WELWYN HATFIELD COUNCIL – DEVELOPMENT CONTROL
DELEGATED REPORT

APPLICATION No:	S6/2007/1627/FP
------------------------	-----------------

The application seeks full planning permission for the erection of a single storey side and rear extension.

S.W. ELEV.

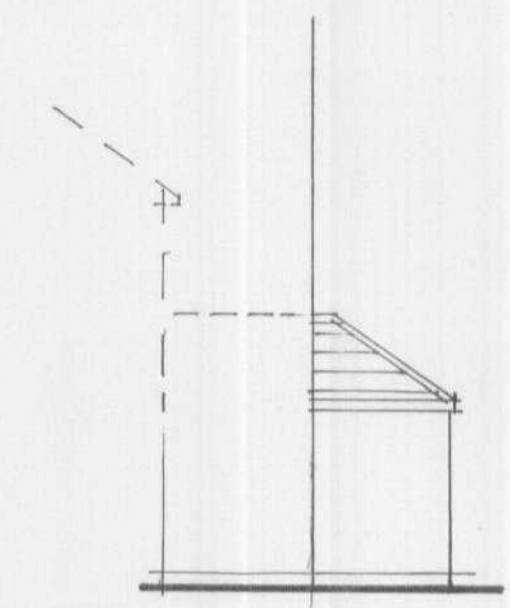
1. C.2.1 - Standard Time Limit - 3 years
2. C.5.1 - Matching materials.
3. The side window to the bathroom of the proposed extension facing the rear boundary of the properties in Buttercup Close shall be glazed with obscured glass and shall be fixed so as to be incapable of being opened below a height of 1.7 metres above floor level, and shall be retained in that form thereafter.

4. Other than the windows shown on the approved drawing to which this planning permission relates, no windows shall be inserted into the ground floor side elevation of the approved extension facing the rear boundary of the properties in Buttercup Close of the development hereby permitted without the prior written consent of the local planning authority.

GROUND FLOOR.

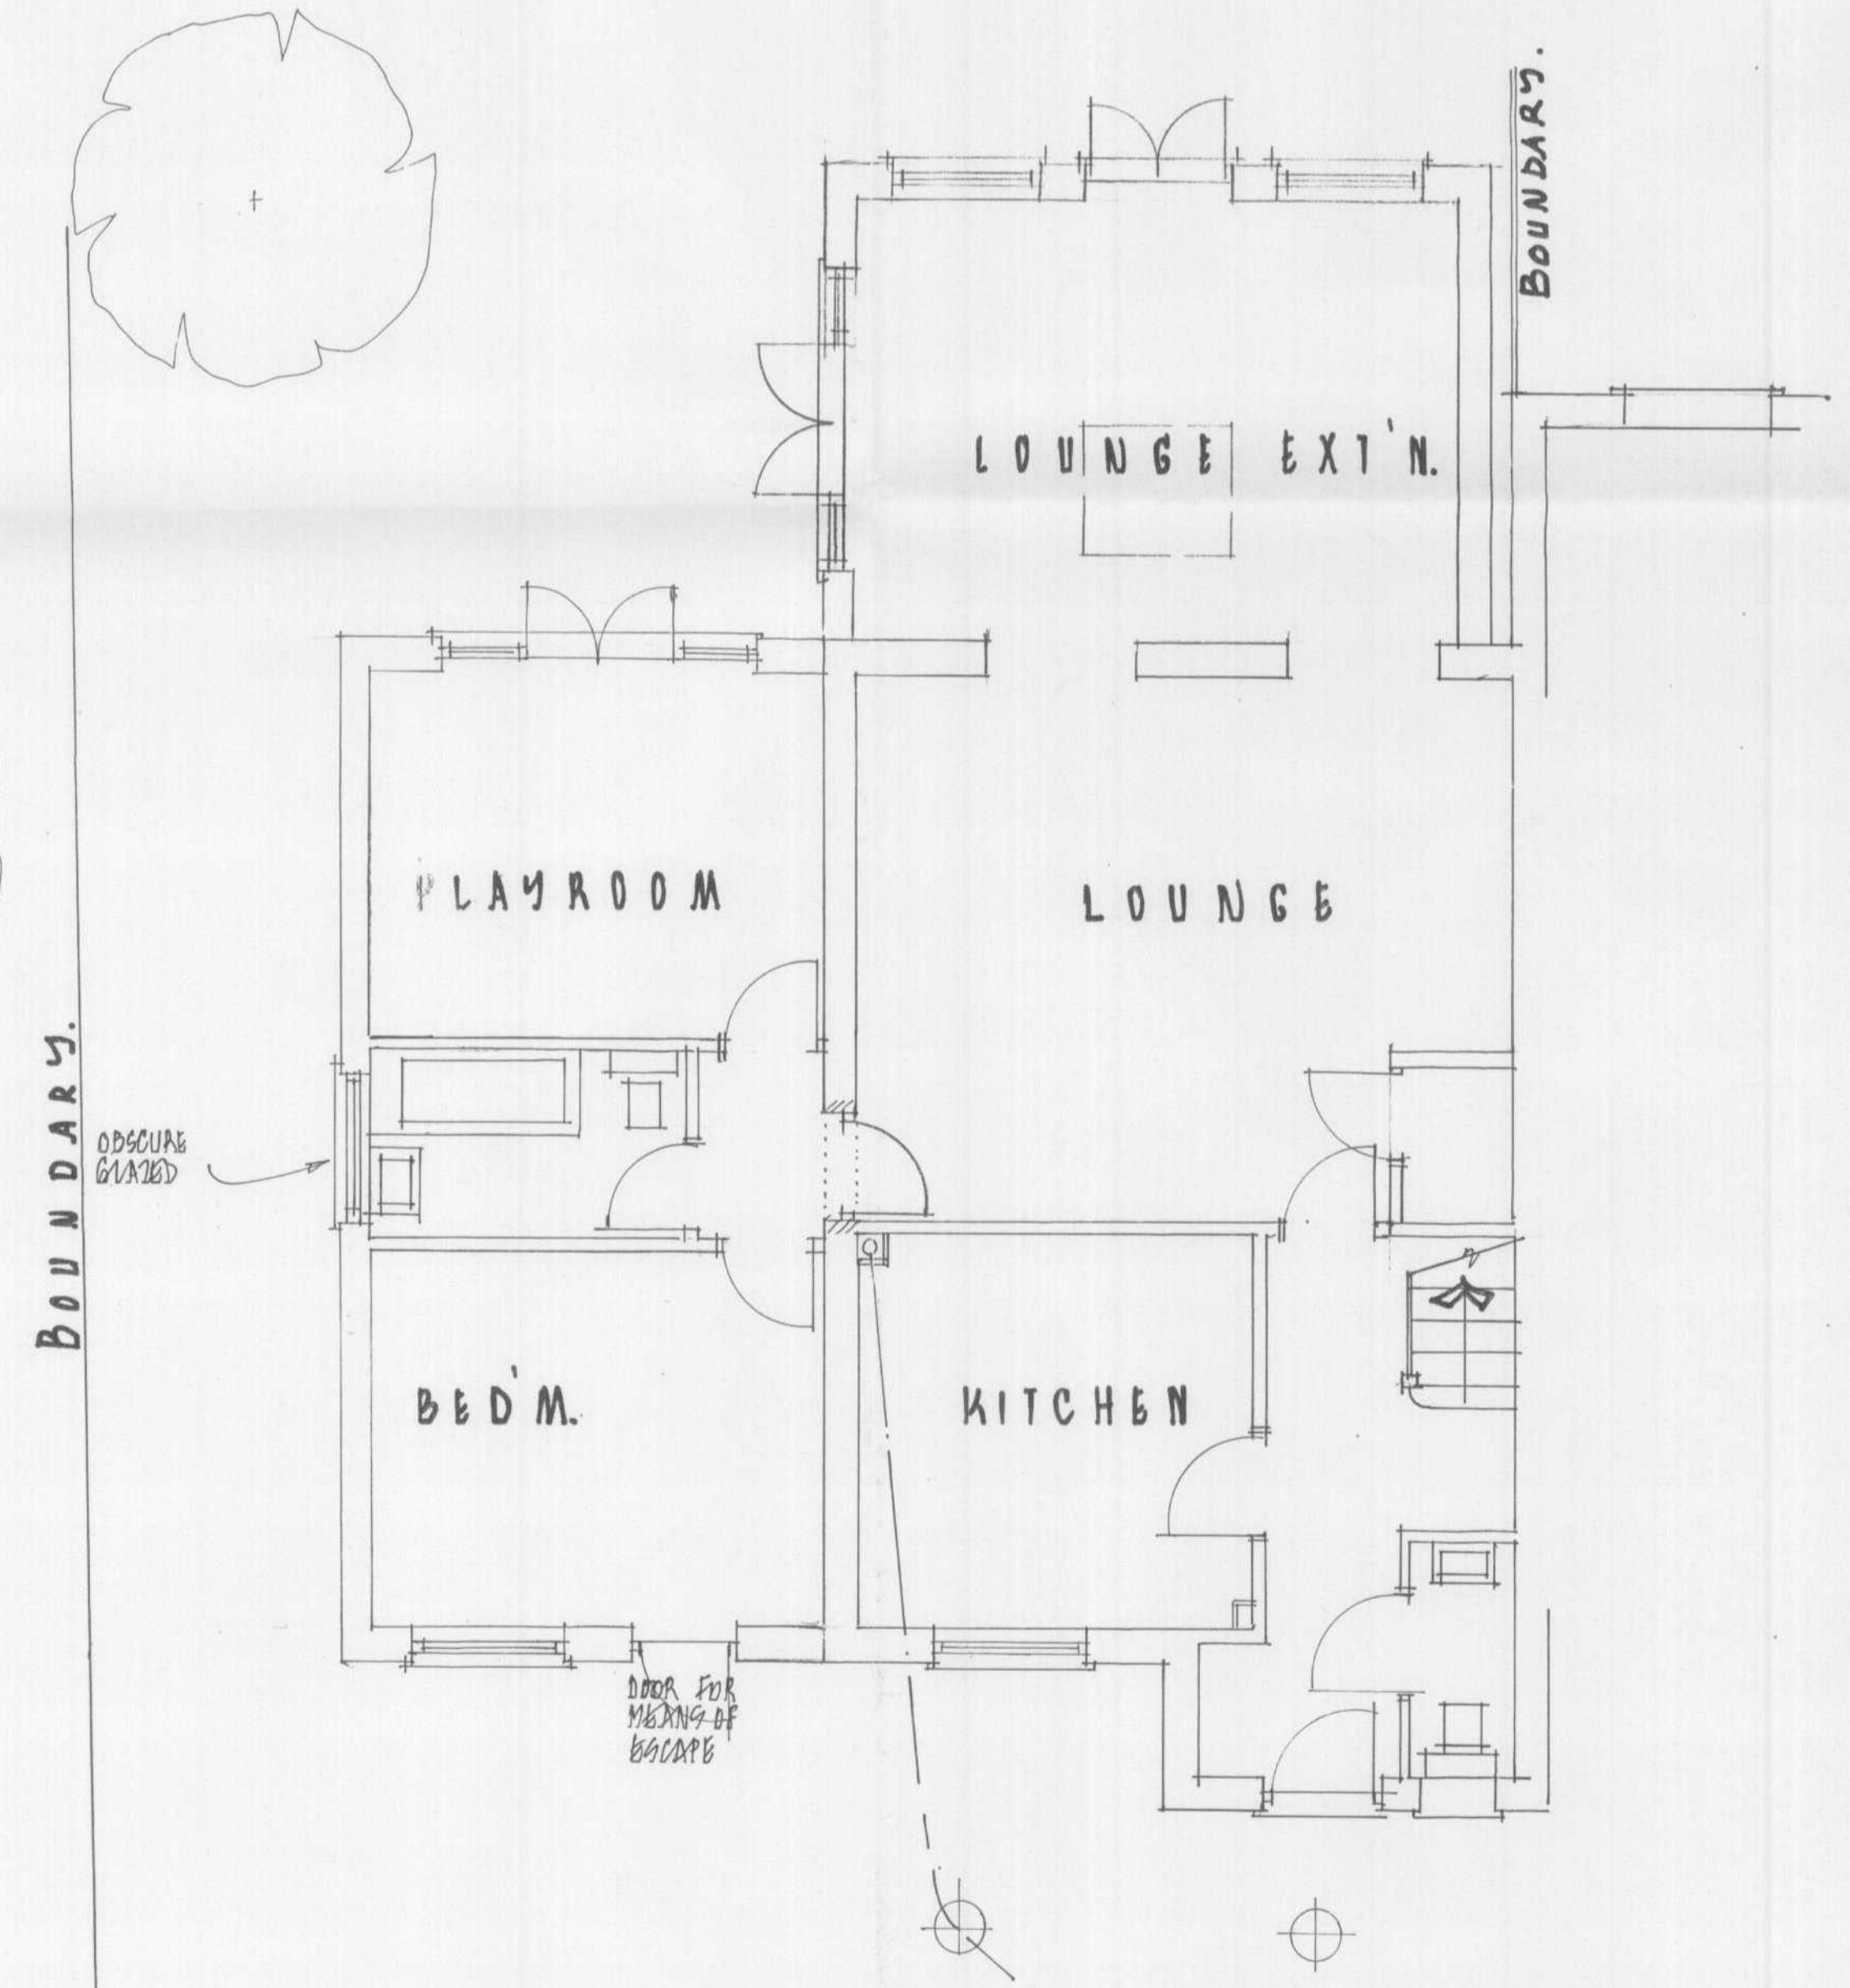
The size of the side extension was a concern on the original drawings submitted, however, the revised drawings have reduced the width by approximately 1m, and although the proposal would significantly increase the ground floor accommodation, when considered with the total floor area of the dwelling including the first floor, the extensions would still appear subordinate in scale.

The visual impact from the rear garden to No.26 Buttercup Close was. However, considered to be a concern bearing in mind the shallow depths of these neighbouring gardens at 6.5m. The revised drawing has increased the separation distance from the side boundary with these neighbours, and on balance, it is now considered that the side extension will not appear overbearing or over dominant. A planning condition would be reasonable requiring the side window to what appears to be a bathroom to be obscure glazed and non-opening below 1700mm above floor level. A further condition to prevent the addition of more side windows would be reasonable due to the very limited depths to the rear gardens of Buttercup Close which only rely on a close boarded fence for screening.
